Please ask for: Ms Iqraa Malik  
Email: [iqraa.malik@terraquest.co.uk](mailto:iqraa.malik@terraquest.co.uk)  
Telephone: 0121 234 1390  
Our Ref: WA/38/25/HH  
Your Ref:  
Date: 6th May 2025

**Application for Planning Permission for Works or Extension to a Dwelling**

**Development:** Demolition of existing swimming pool house and construction of new Swimming Pool House  
**Location:** Little Danes Yapton Lane Walberton BN18 0LS

EAST

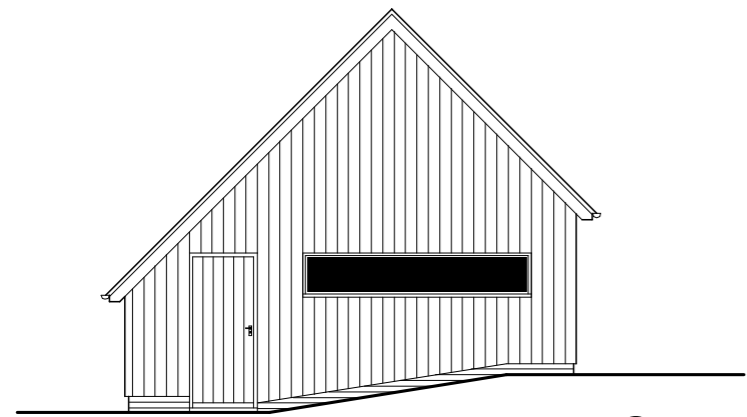
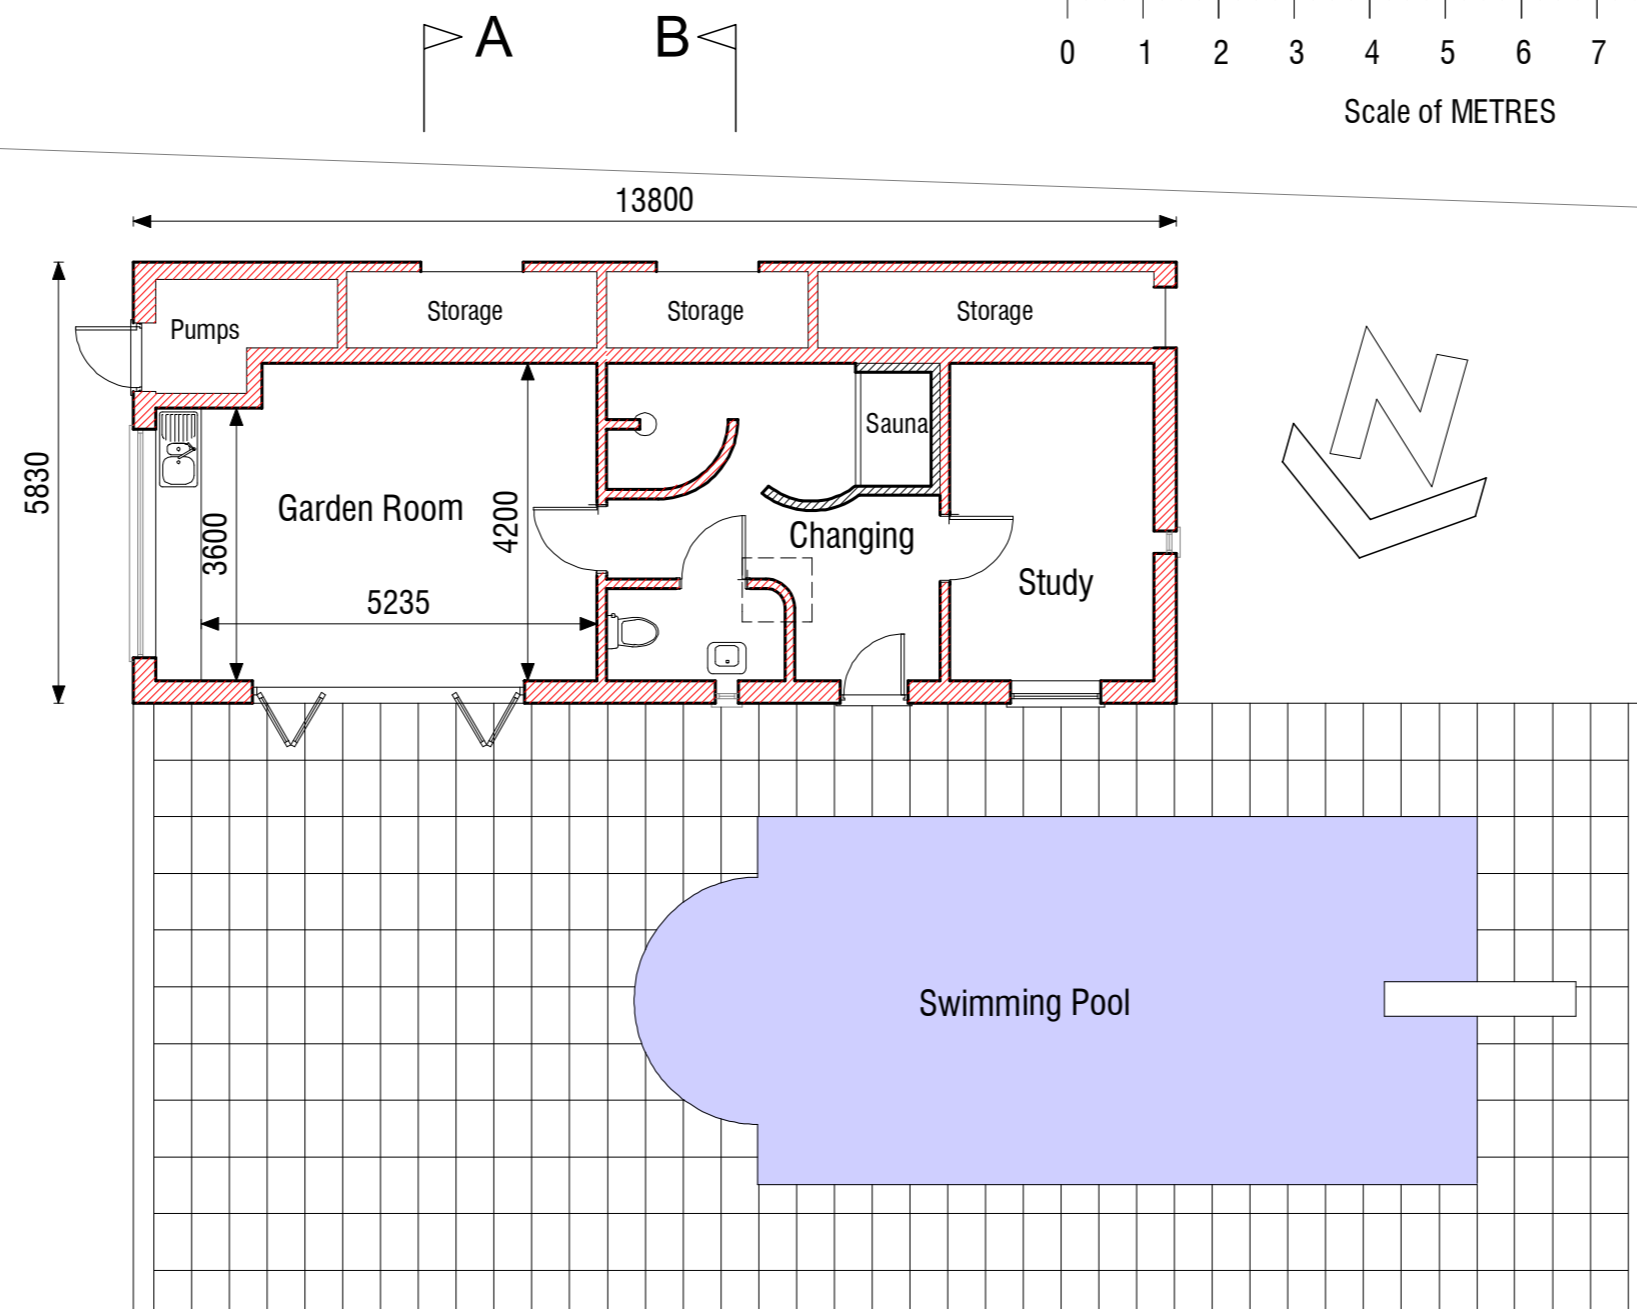
The proposed east elevation is inconsistent with the proposed ground floor plan, please review and amend accordingly.

ROOF PLAN

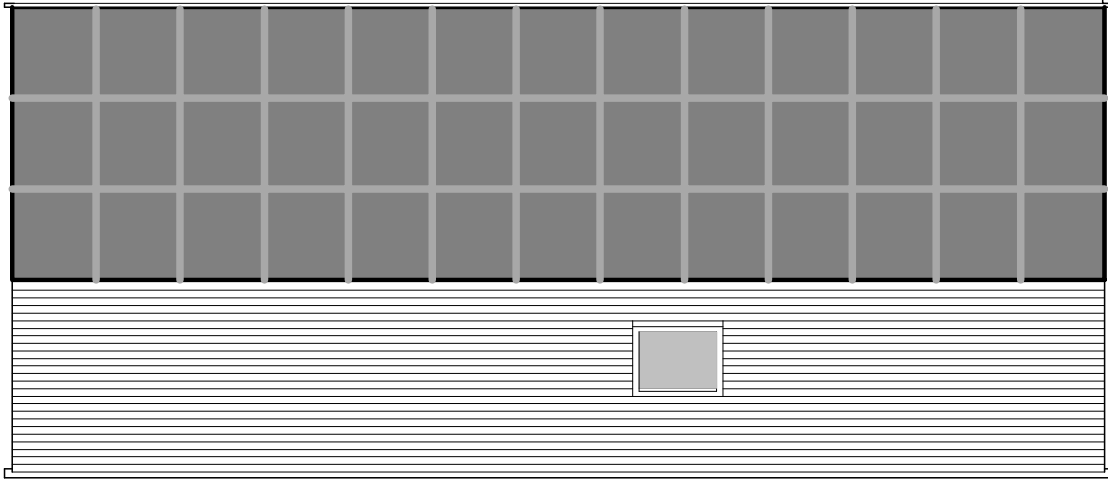
Please submit electronic plans showing the proposed roof plan, or show the proposed rooflight on the proposed ground floor plan. Please refer to the Validation Requirements List for further details.
